ENG-SF22035-R1-FDR.pdf Markup Summary

SF2235

November 2022

DESIGNED BY	MAL	SCALE	DATE	08/31/22
DRAWN BY	MES	(H) 1"= 2'	SHEET 47 OF 53	
CHECKED BY		(V) 1"= N/A	JOB NO.	1183.30

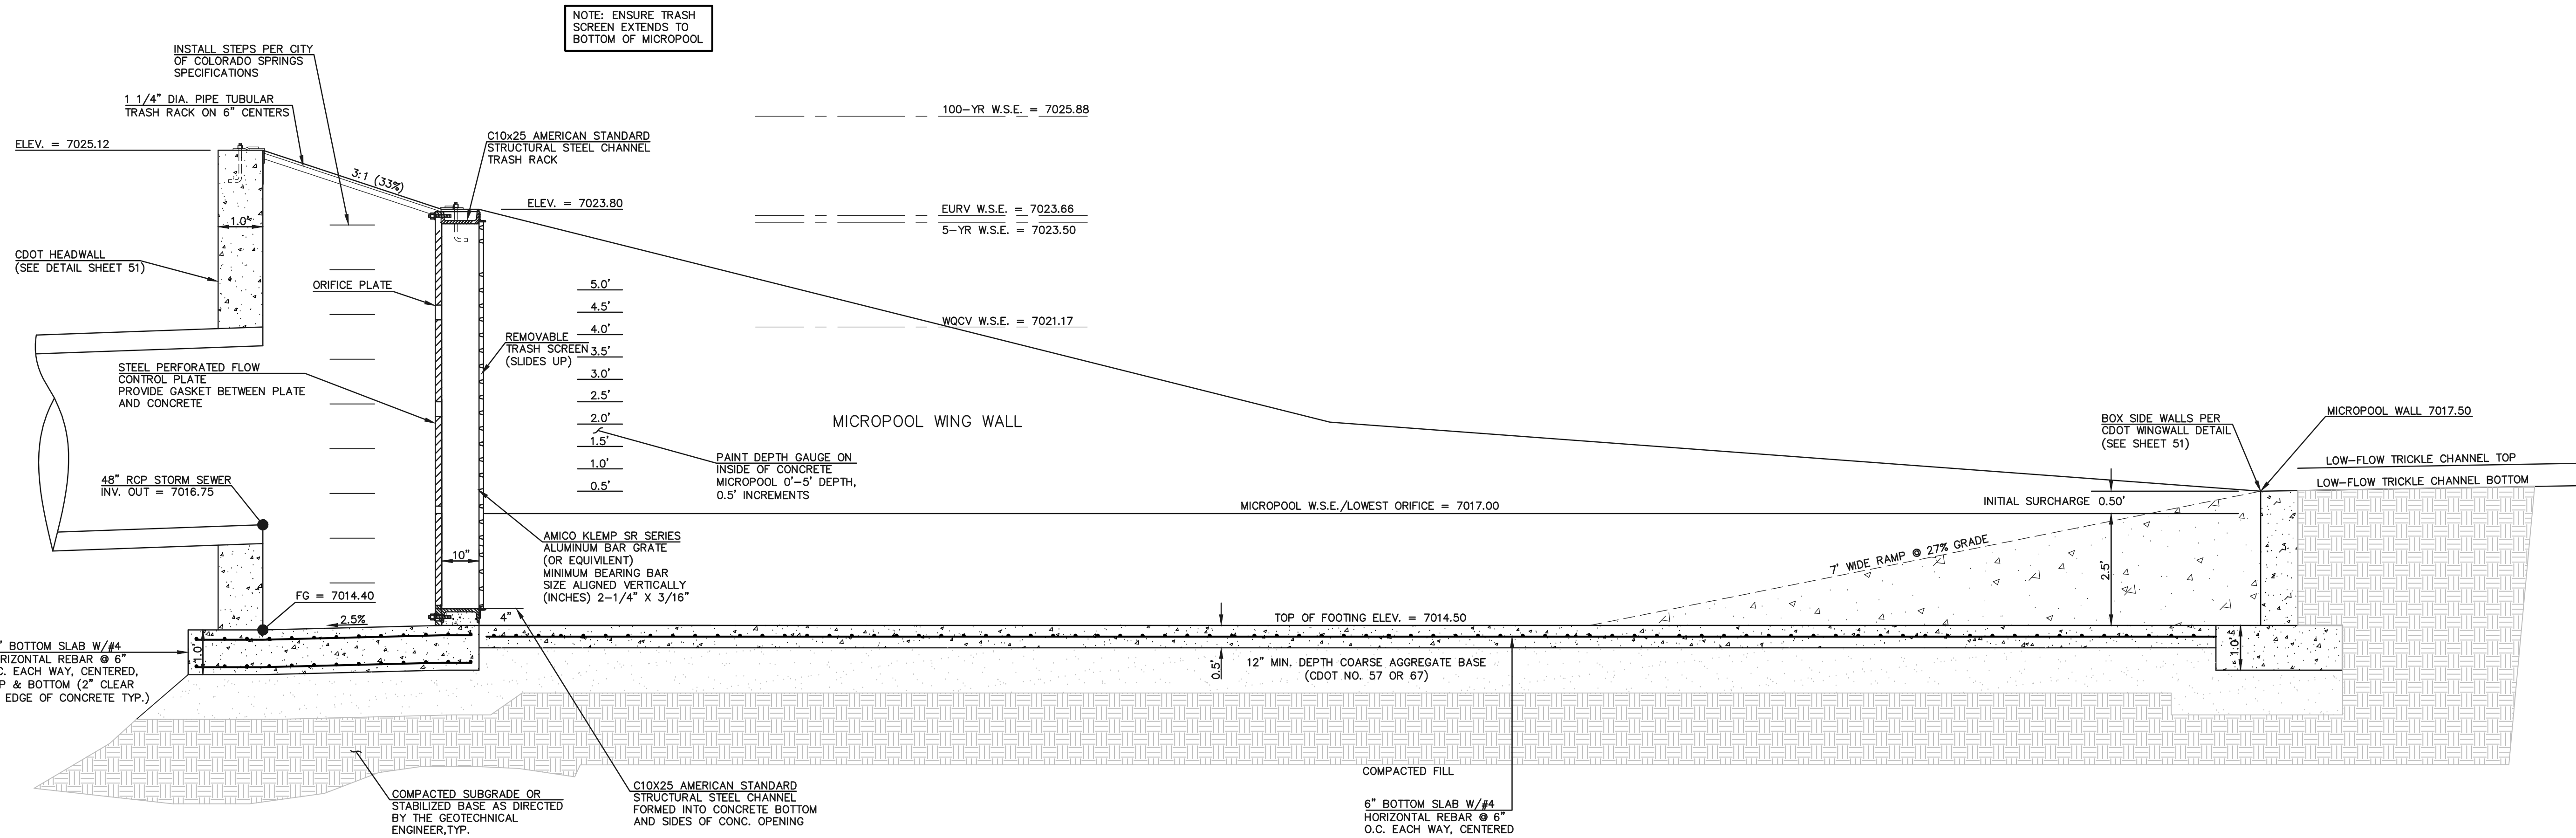
3.0 on Sht 47 of CD's

POND '14A'
POND OUTLET BOX AND MICROPOOL DETAILS

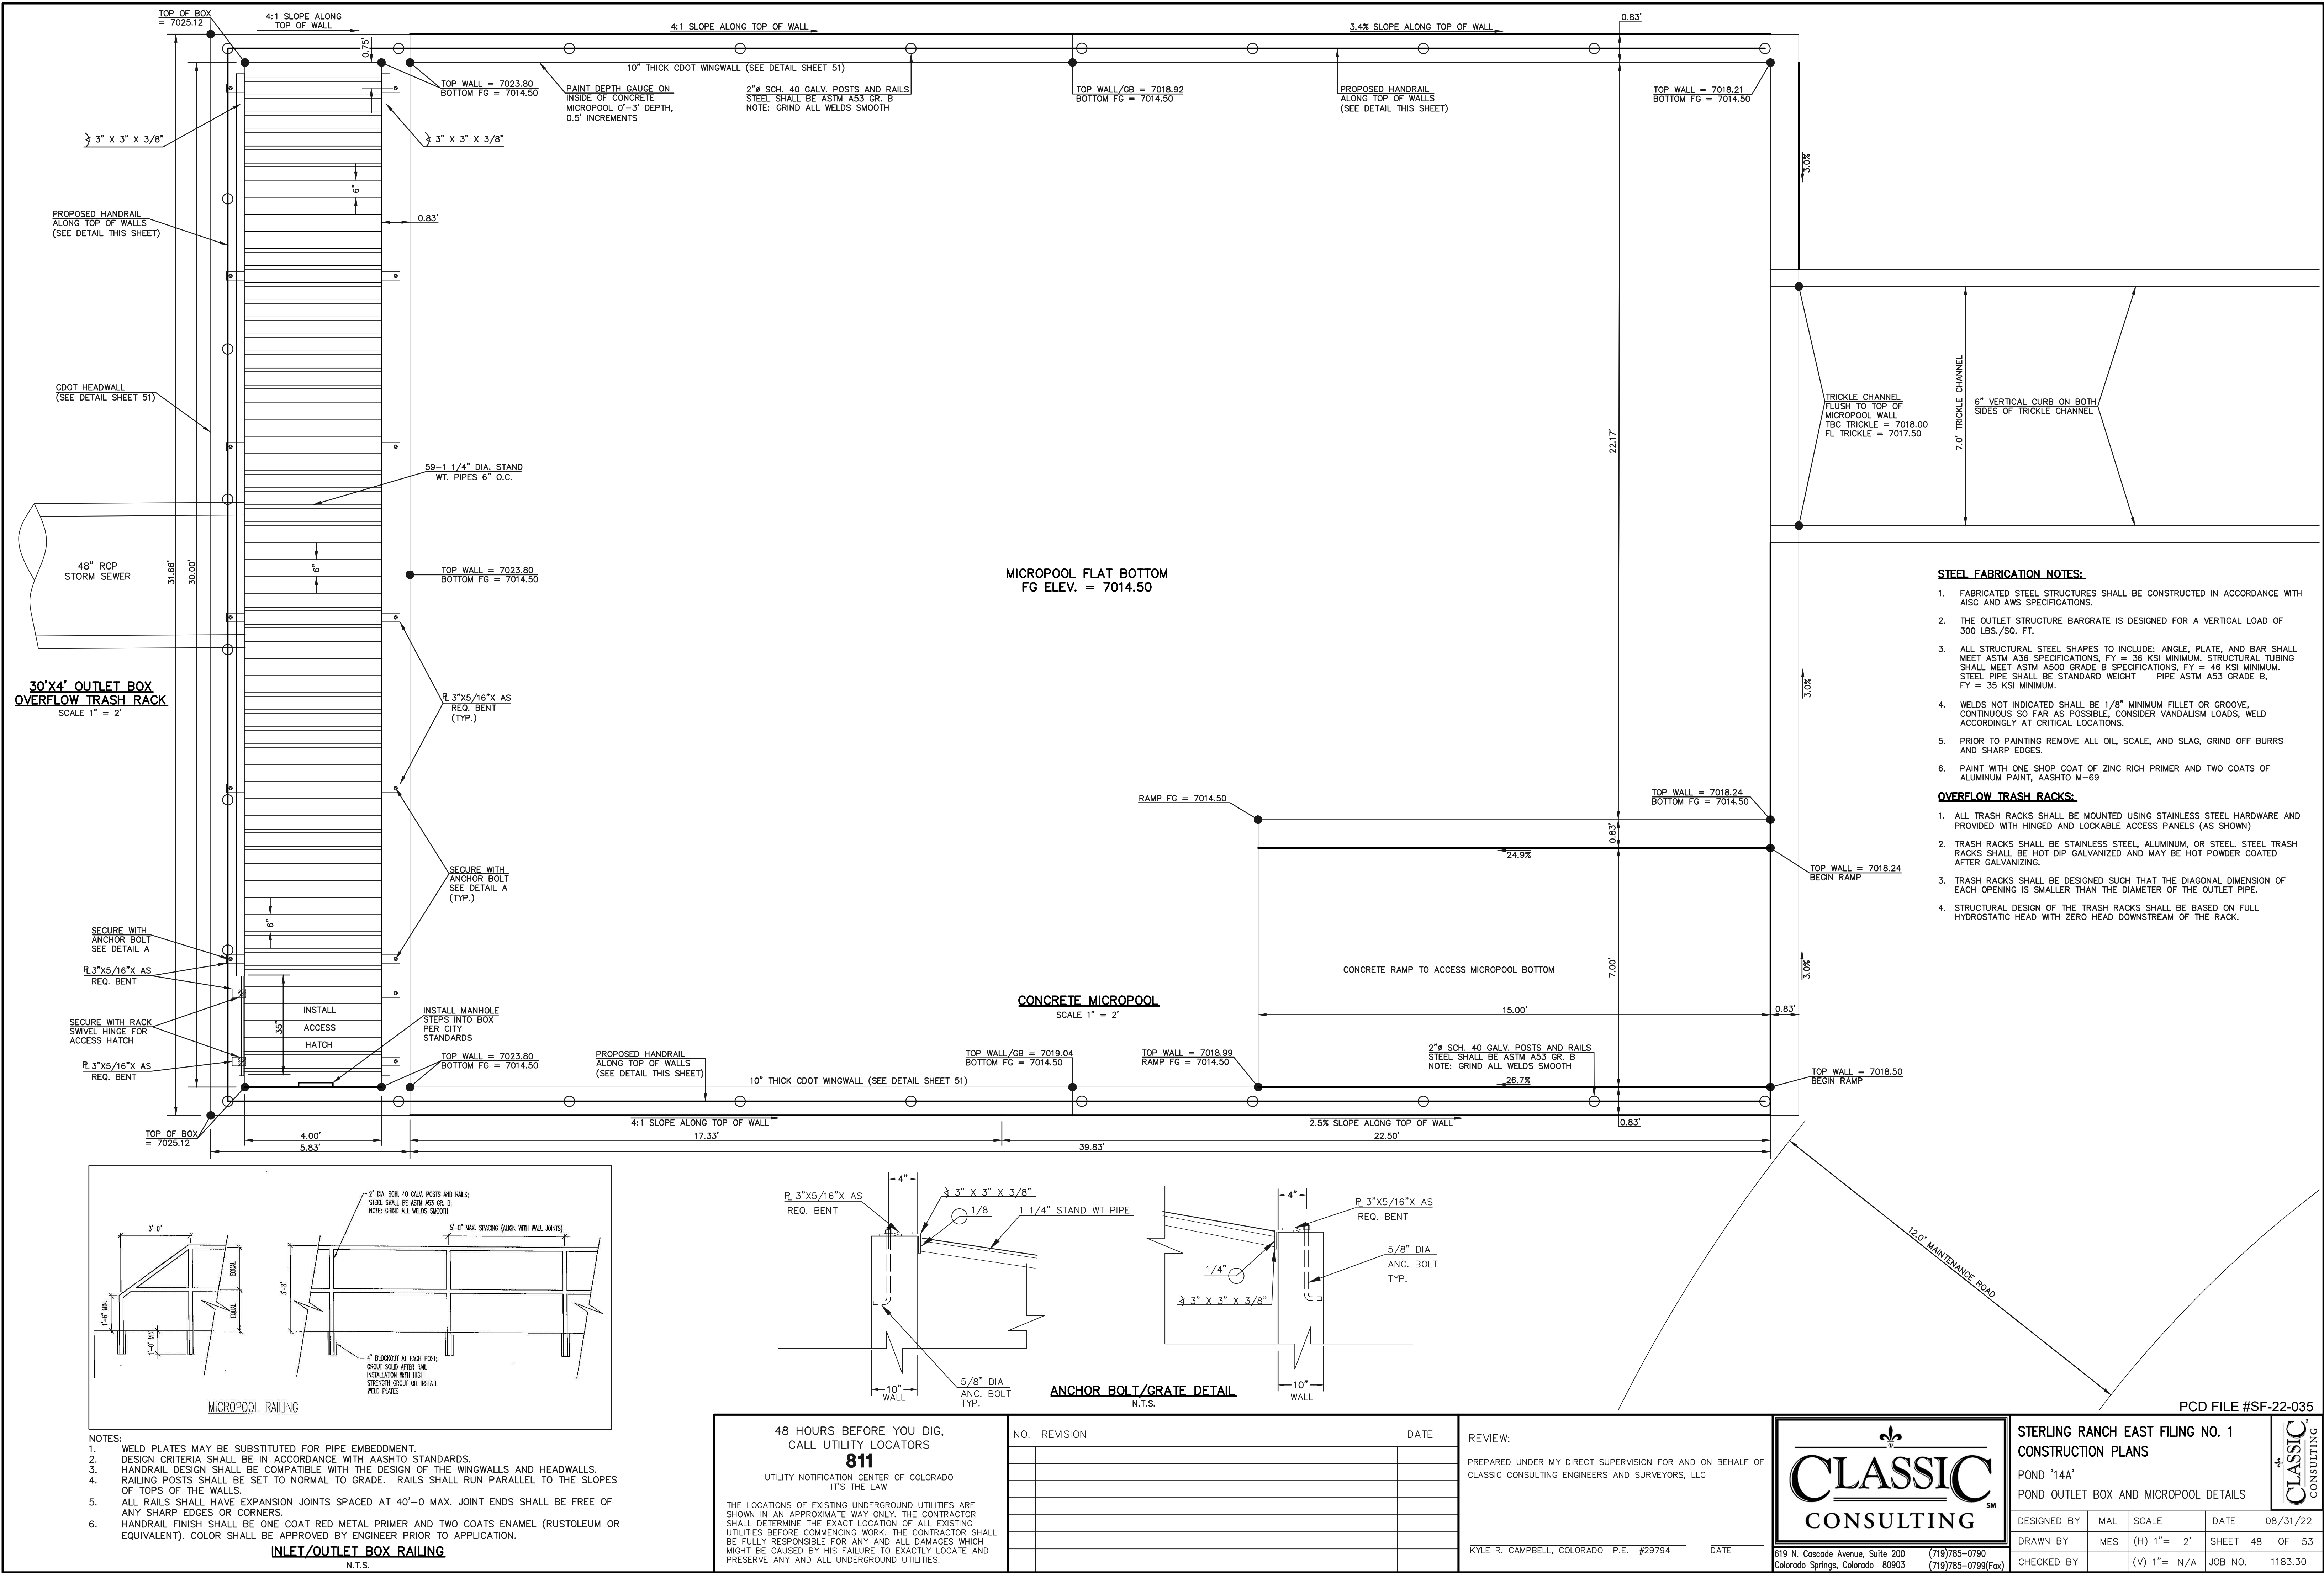
22.17ft on Sht 48 of CD's
